Subject: Tire Warehouse Portland, ME
From: GEORGE CLOSSON (george.closson@anet.net)
To: rpmarchitecture@gmail.com;
Date: Tue, 28 Jun 2011 14:18:30

Door Header Design
 DOTEN'S CONSTRUCTION INC

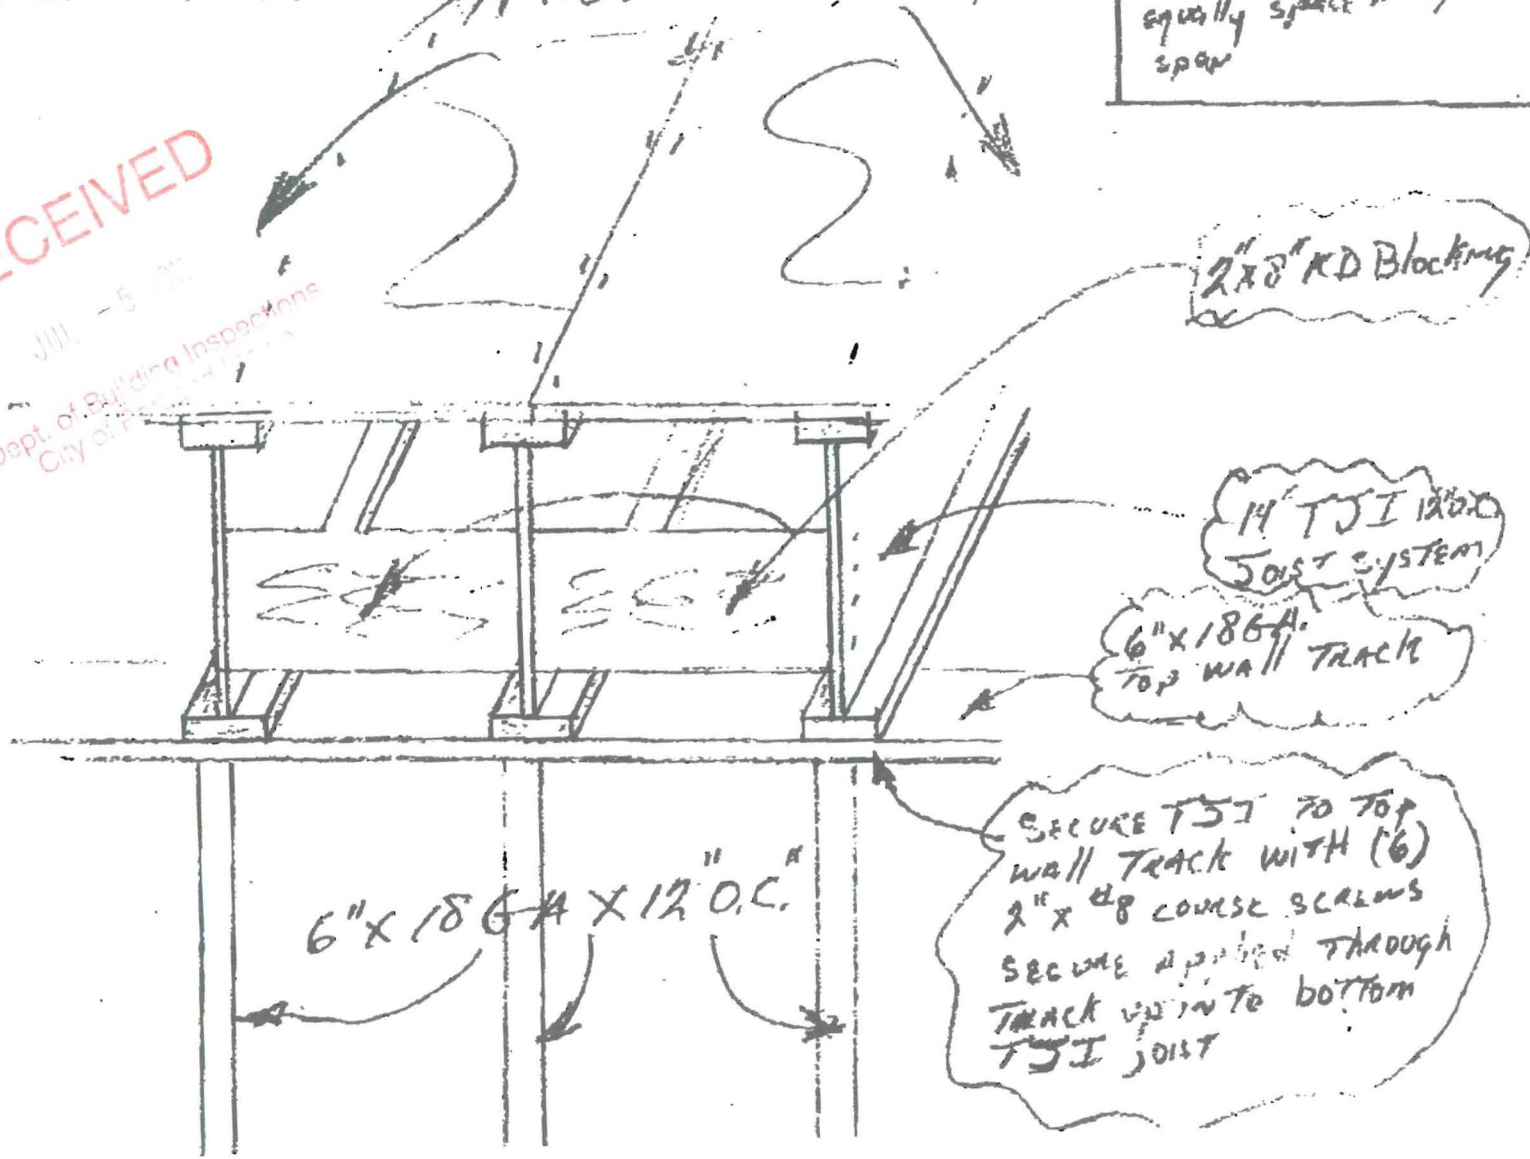
We just had an inspection on the wall framing. The inspector wants details on the interior door openings headers. My contractor on site suggests using 2 6" X 18 ga studs on their sides capped with 6" X 18 ga track fastened at each end with an "L" clip top and bottom fastened with 6 #10 screws.

Also, as I discussed with you he has used steel studs for the wall framing in place of the 2 X 6 wood you have on the plans. On the customer service walls he used 18 g metal studs 12" OC to hold the second floor decking.

The alignment bay walls he used 20 ga (floor to ceiling) metal studs 16" OC.

The above is acceptable. Attachment of alignment bay studs at the ceiling must be to solid rafters or solid blocking.

Acceptable for Door Headers
 Robert P Mocarlsky
 Maine Lic APR 2239
